EPC STORMWATER REVIEW COMMENTS
IN ORANGE BOXES WITH BLACK TEXT

GUNTZELMAN PORCELAIN PINES SUBDIVISION

GRADING AND EROSION CONTROL PLAN

COUNTY OF EL PASO, STATE OF COLORADO
FEBRUARY 2023

GRADING & EROSION CONTROL DETAILS

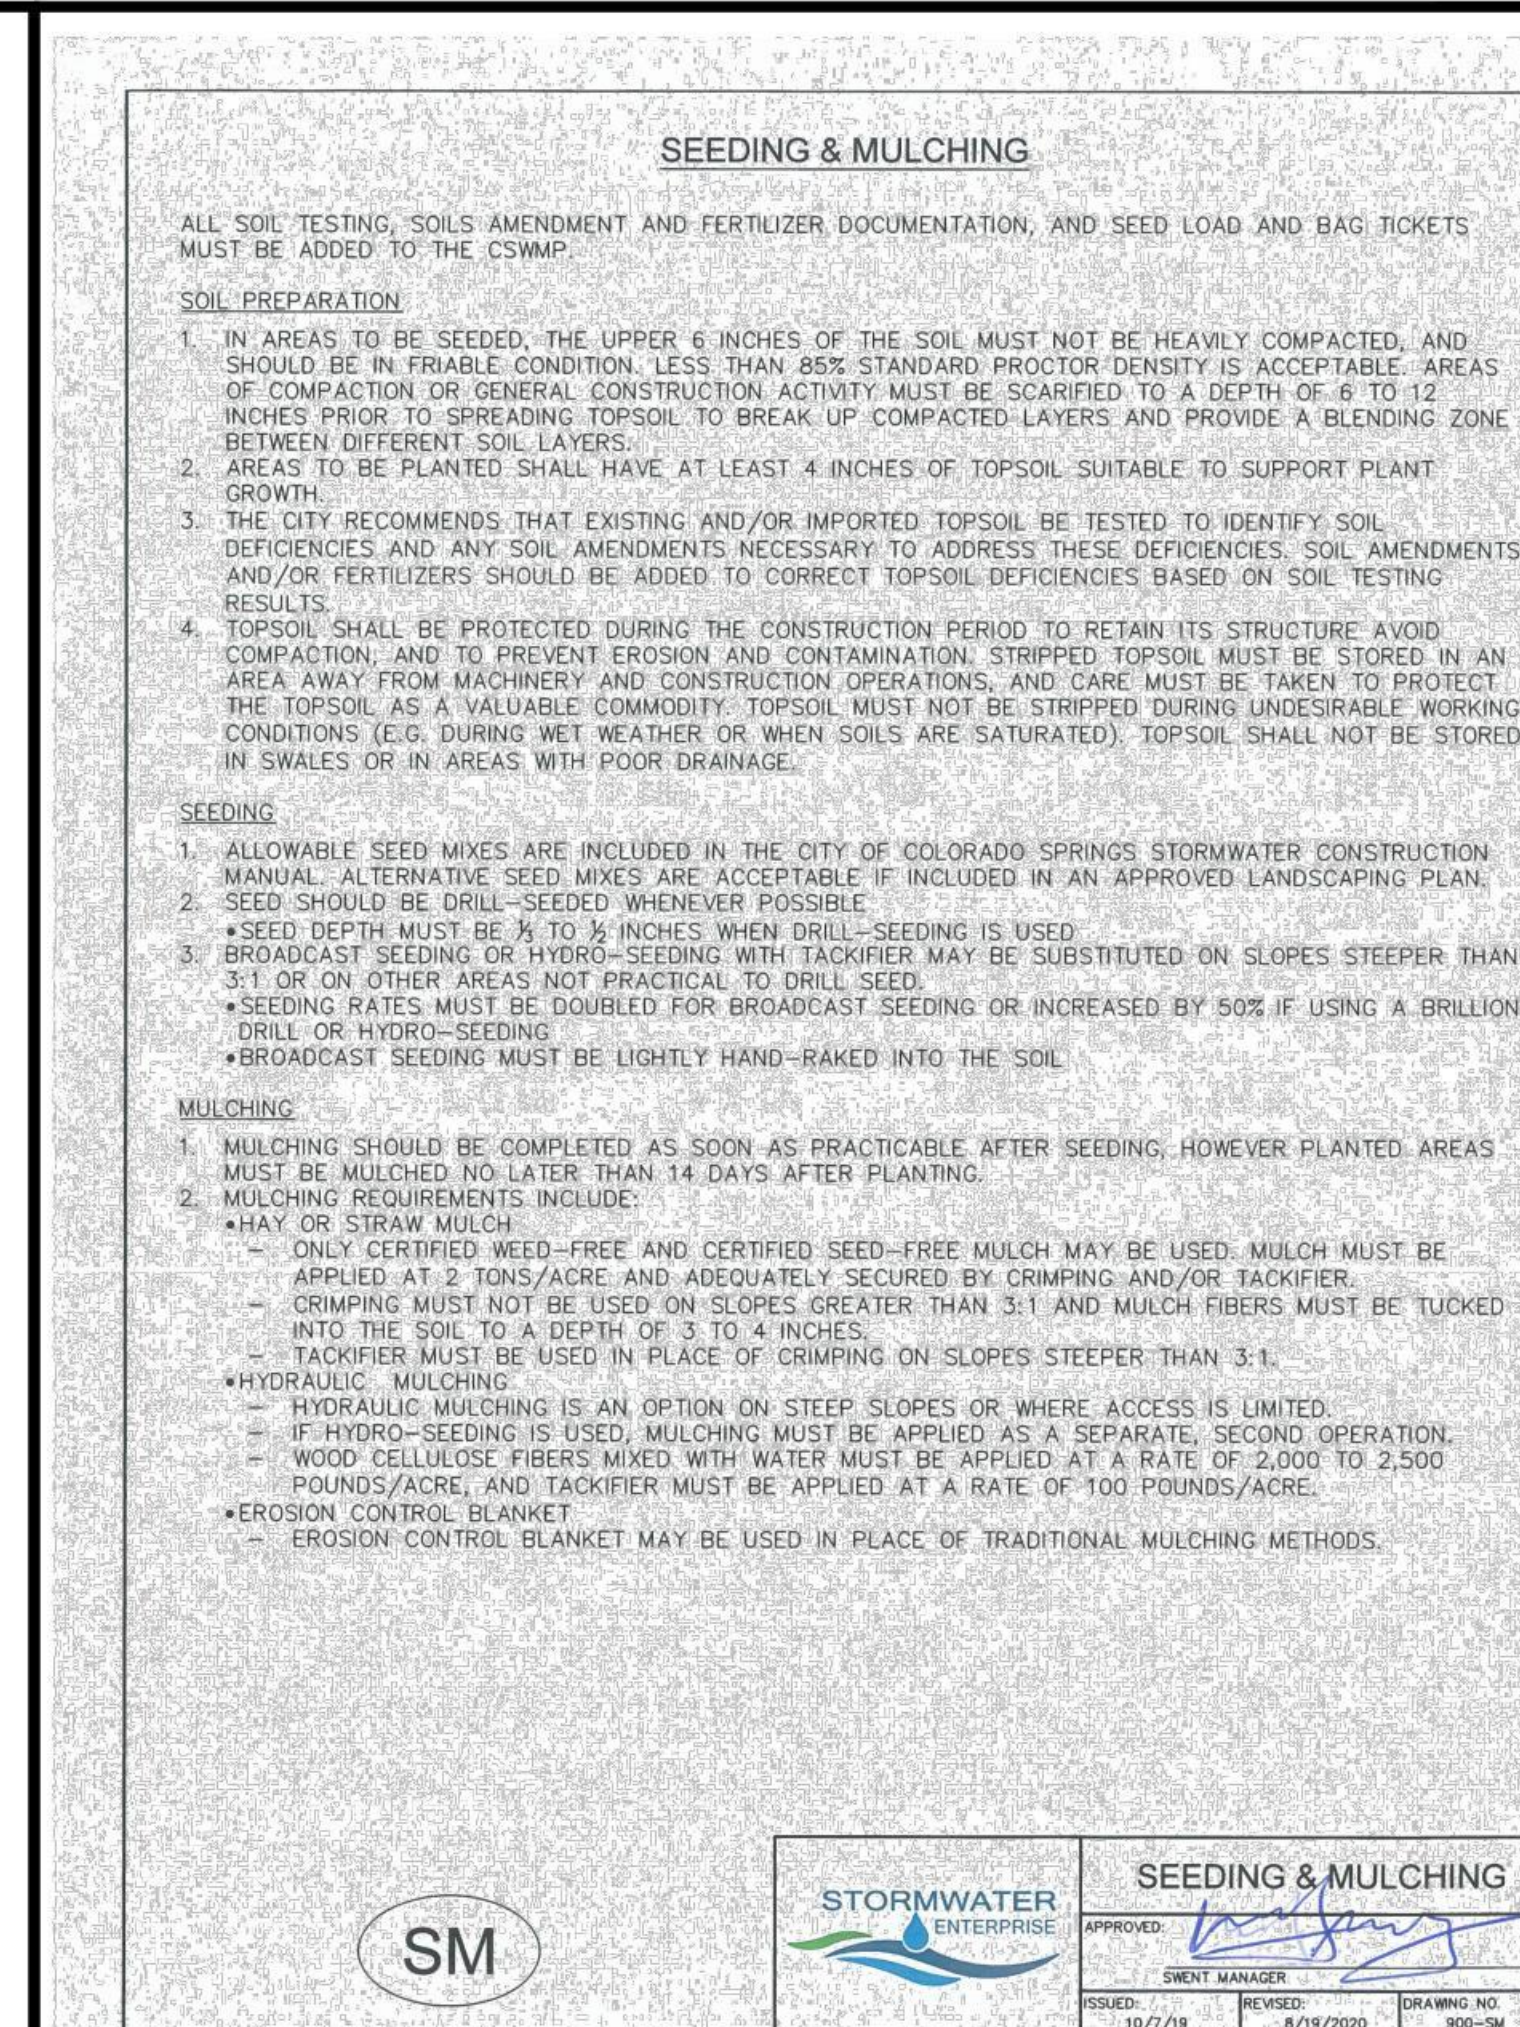
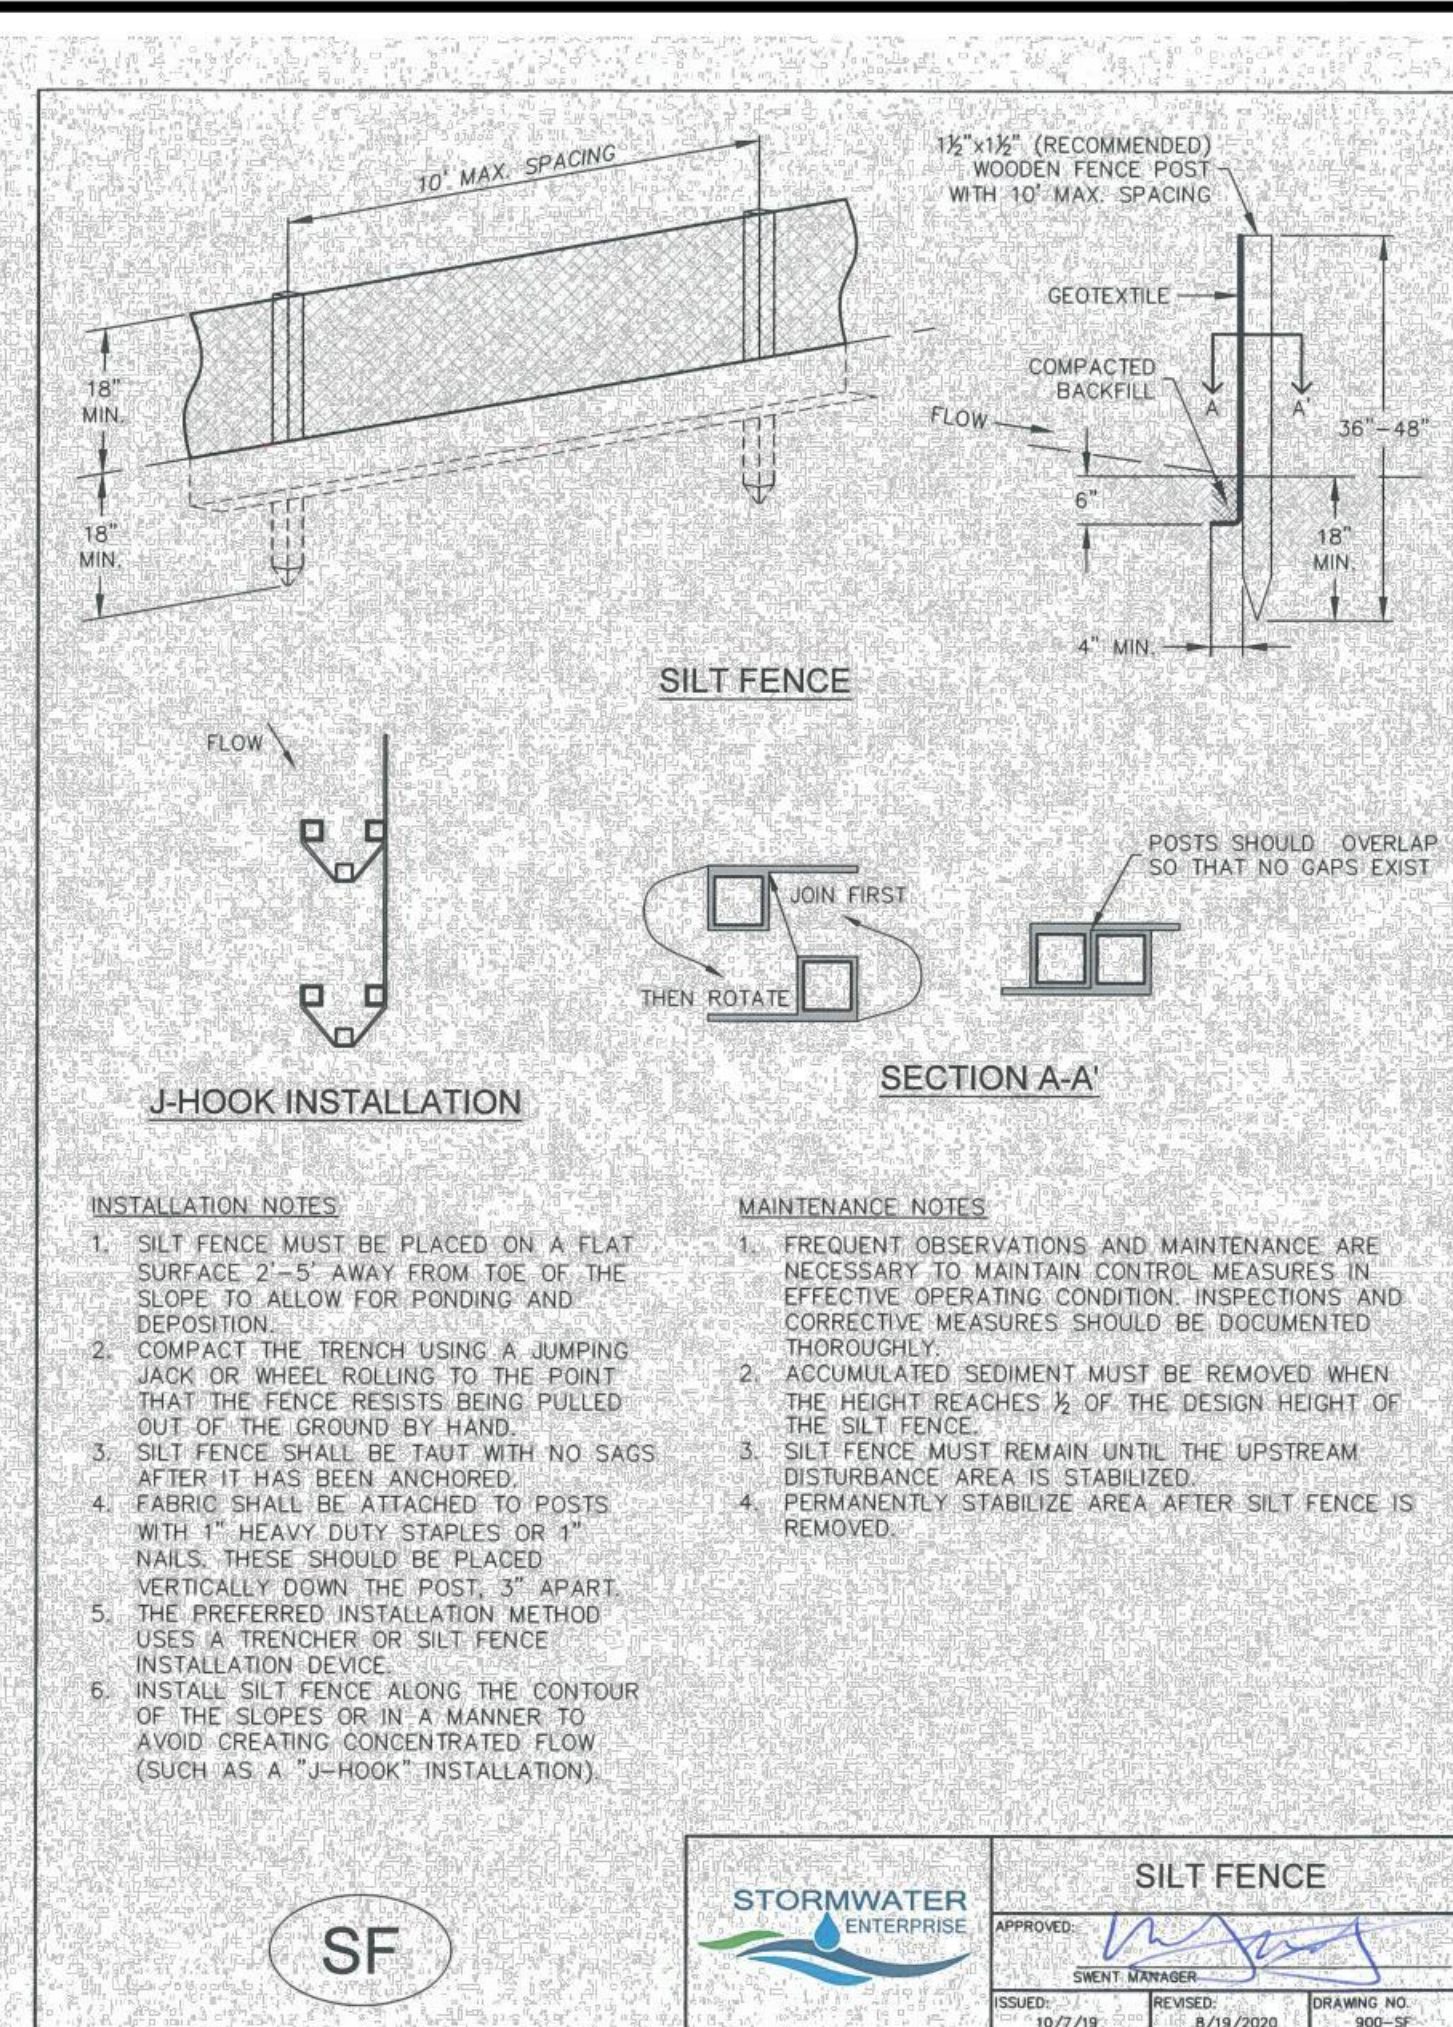
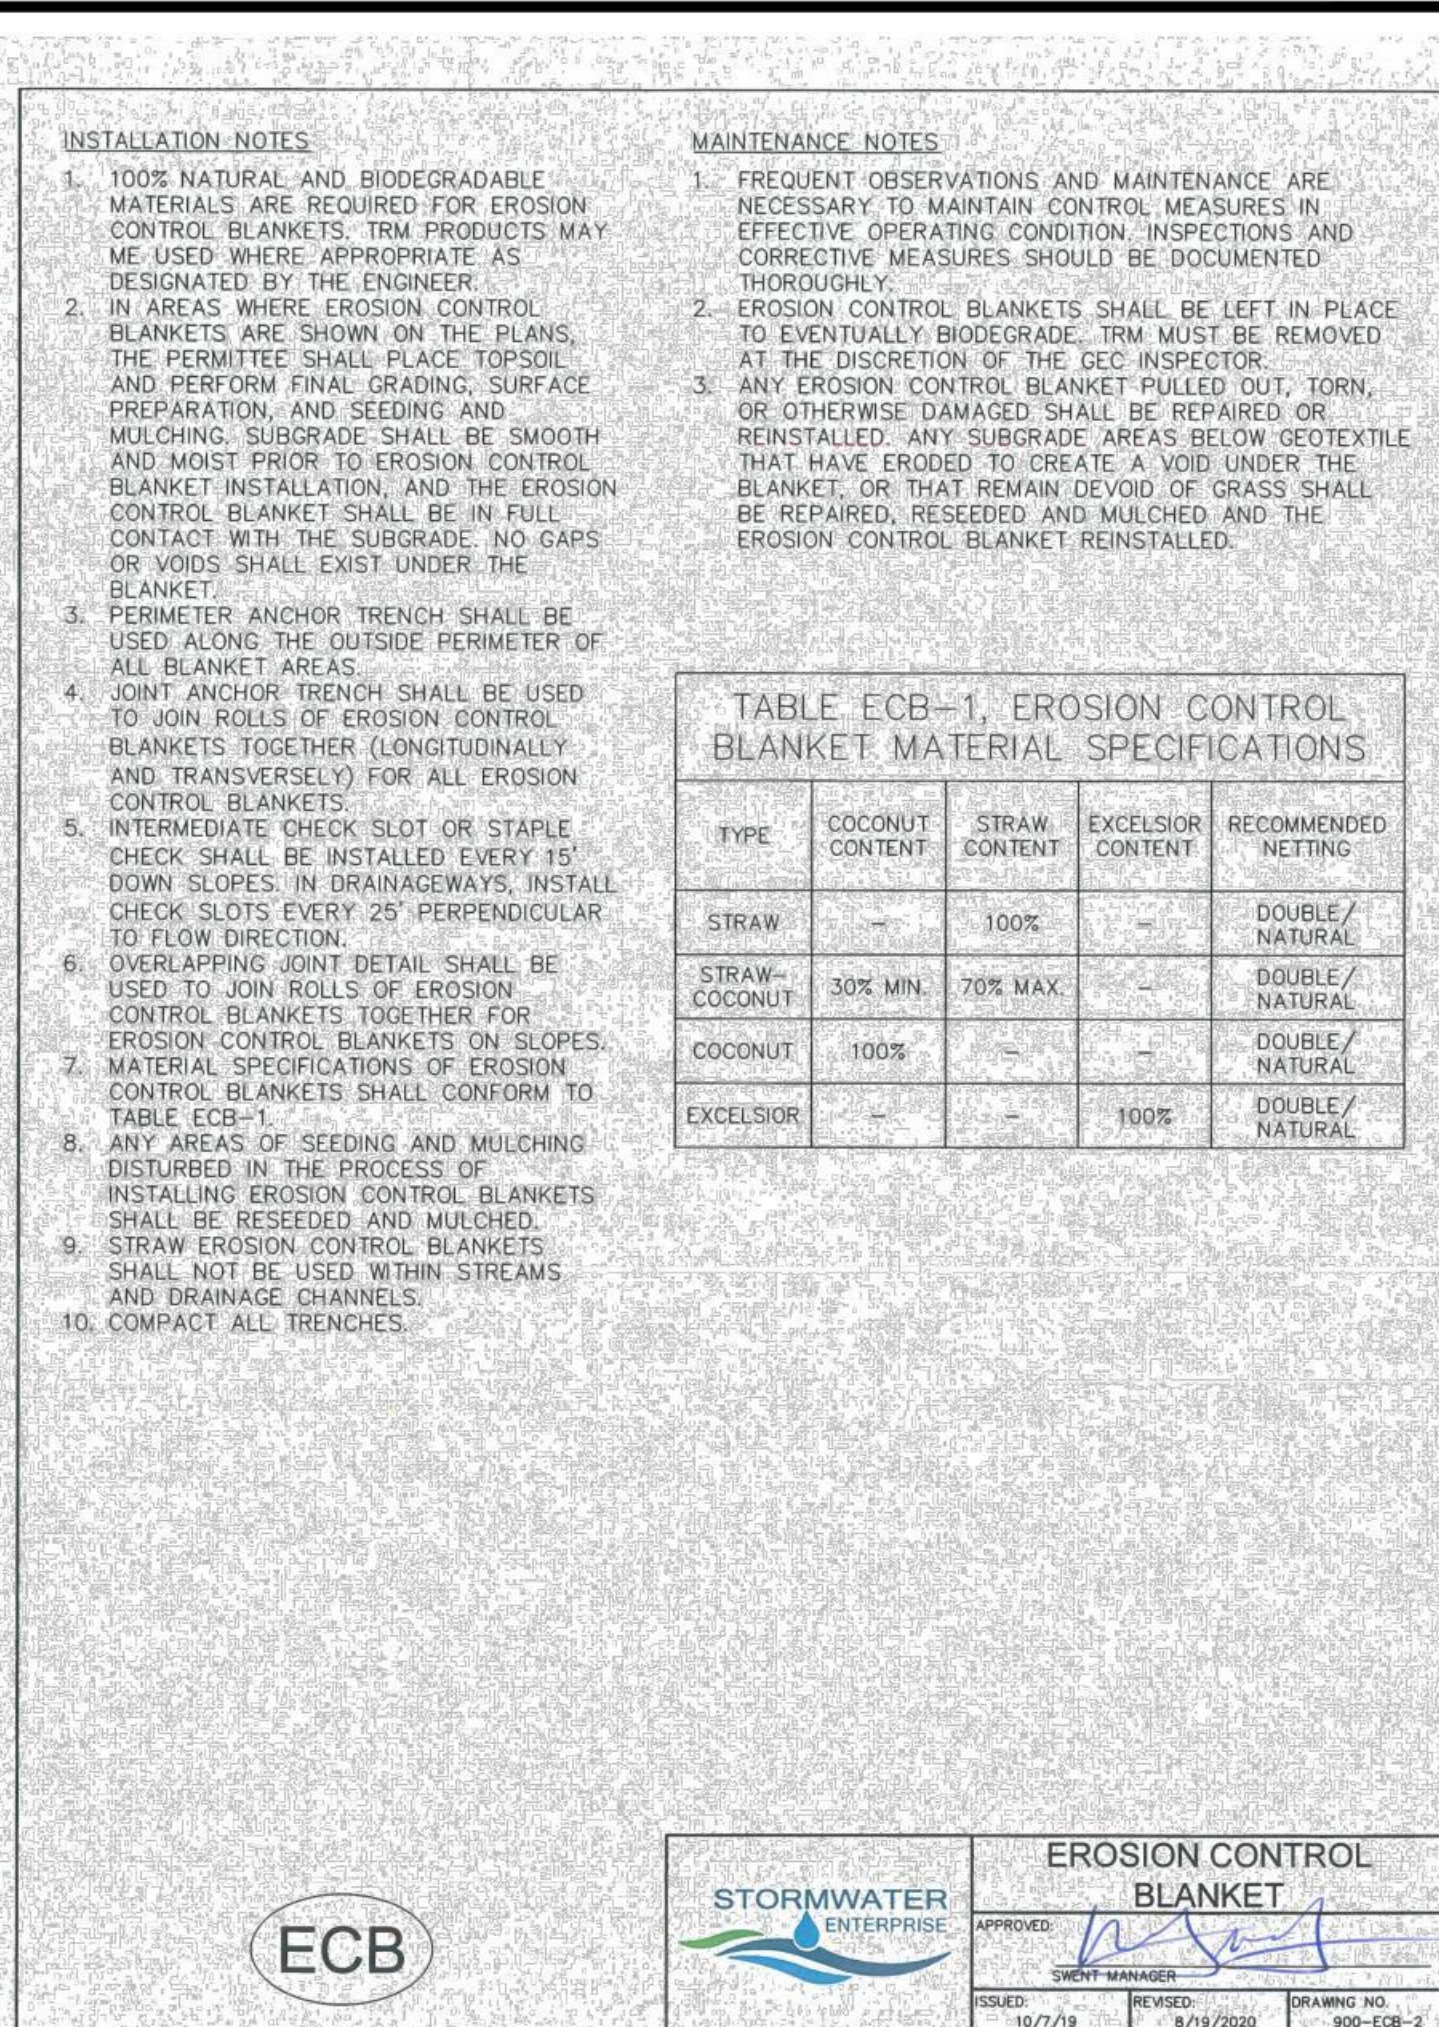
expand to fill white space so that notes are legible when printed.
